RE: Calvin Stanford Short Plat, File Number SP-07-106

Kittitas County Community Development Services has determined that the Calvin Stanford Short Plat (SP-07-106) is a complete application and hereby grants **conditional preliminary approval** subject to the following conditions:

Calvin Stanford Short Plat (SP-07-106)

DRAWN BY: MMJ
CHECKED BY: D.S.G.
PROJECT NO. 06216
SHEET 1 OF 2

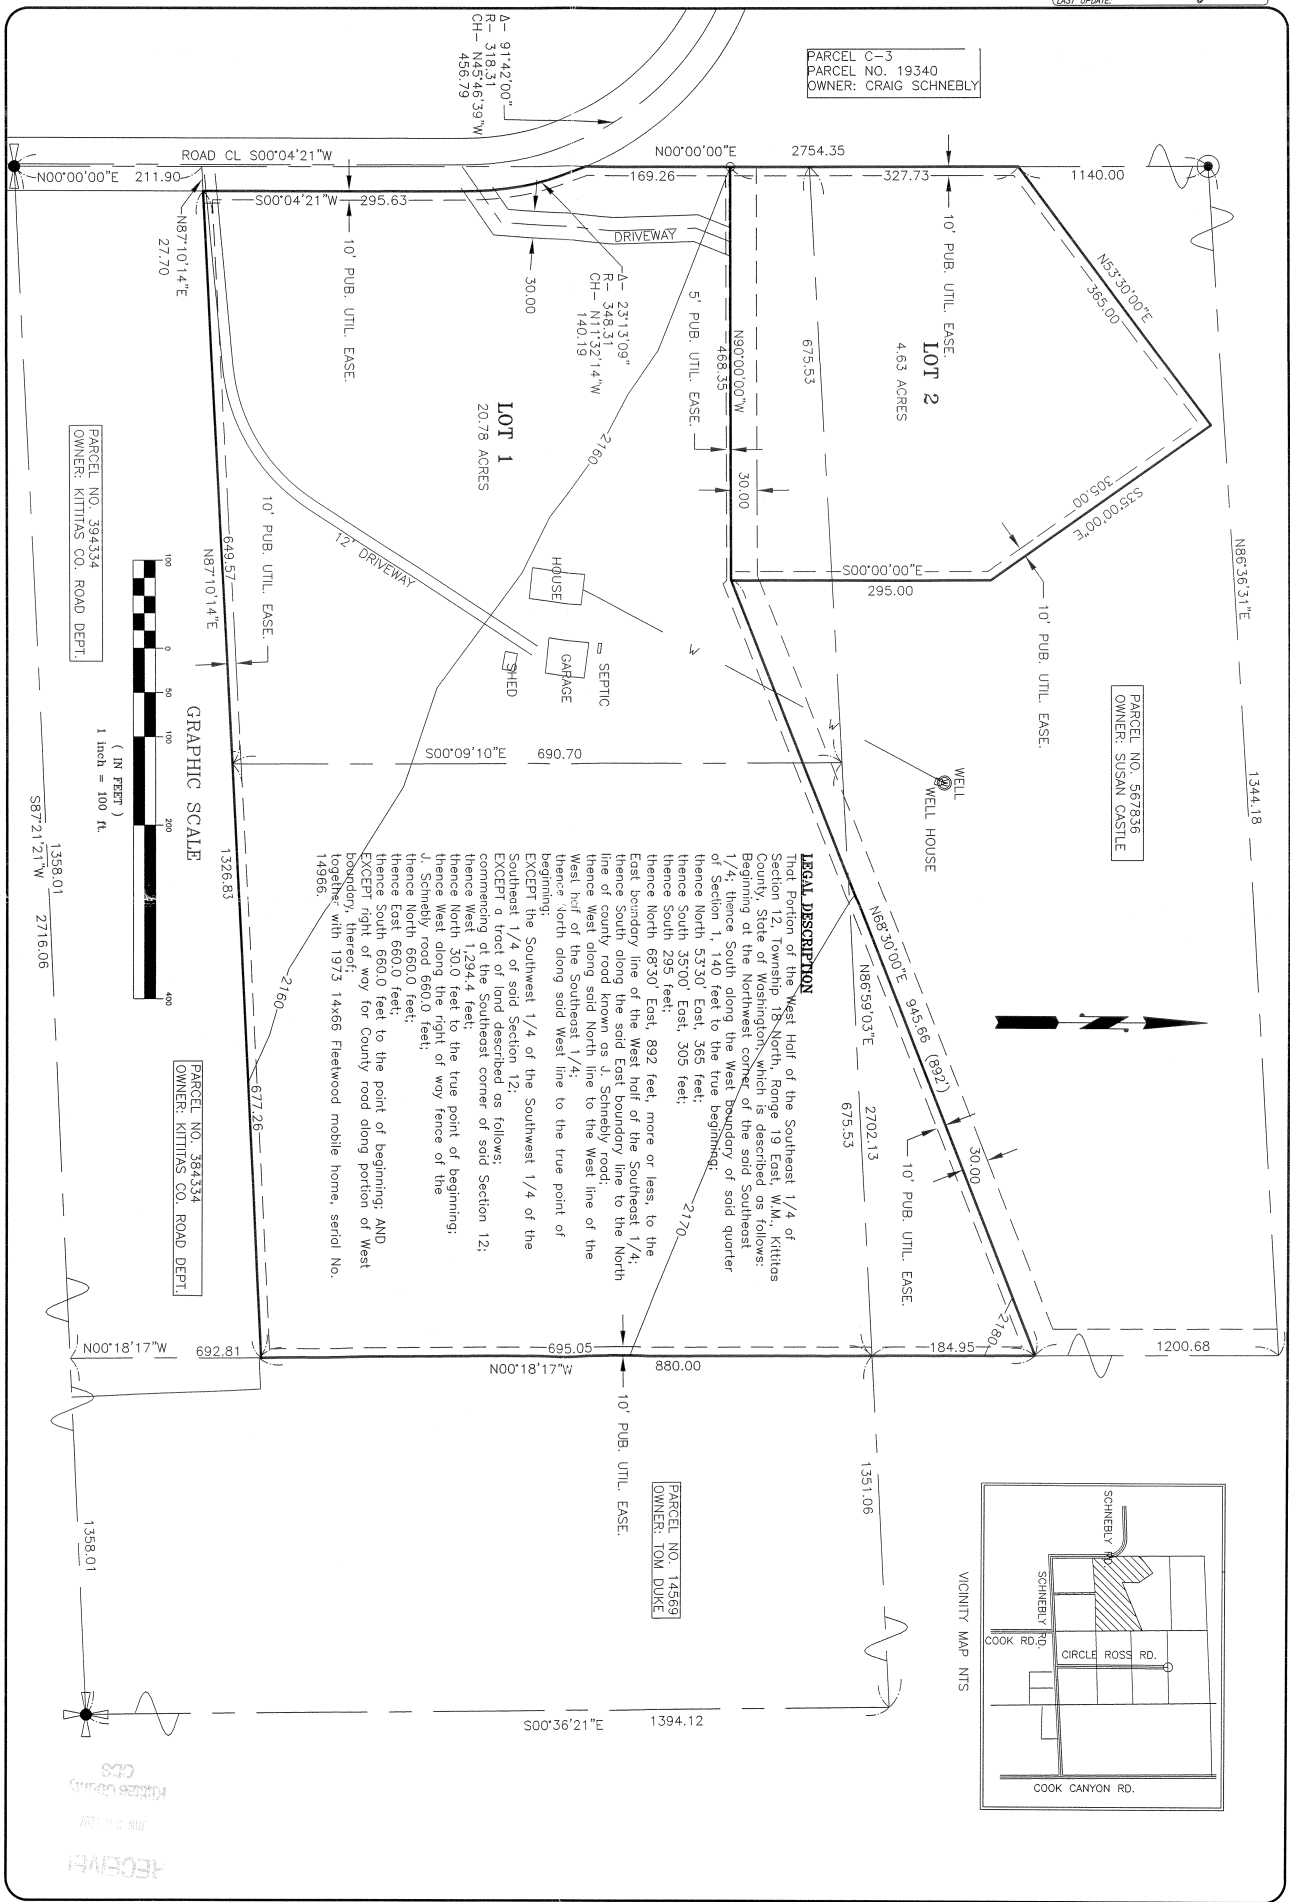
- 1) Both sheets shall reflect Short Plat Number SP-07-106.
- 2) The preliminary drawings submitted to Kittitas County community Development Services contained a Legal description overlapping the Survey Drawings on sheet one. Said error shall be removed from the Final Mylar versions of the Short Plat Drawings.

- 3) The subject parcel of the Calvin Stanford Short Plat is bisected by Coleman Creek in the northwest section of the property. (See Lot 2 of the preliminary short plat drawings.) Coleman Creek shall be clearly delineated and labeled on the final mylar drawings.

- 4) In conformance with Kittitas County Code 16.20.040(17), plat drawings shall depict the location of all ditches whether apparent or of record. The final mylar drawings for the Calvin Stanford Short Plat shall depict the location of the ditch which runs north to south on the east section of Lot 1 of the preliminary short plat drawings.
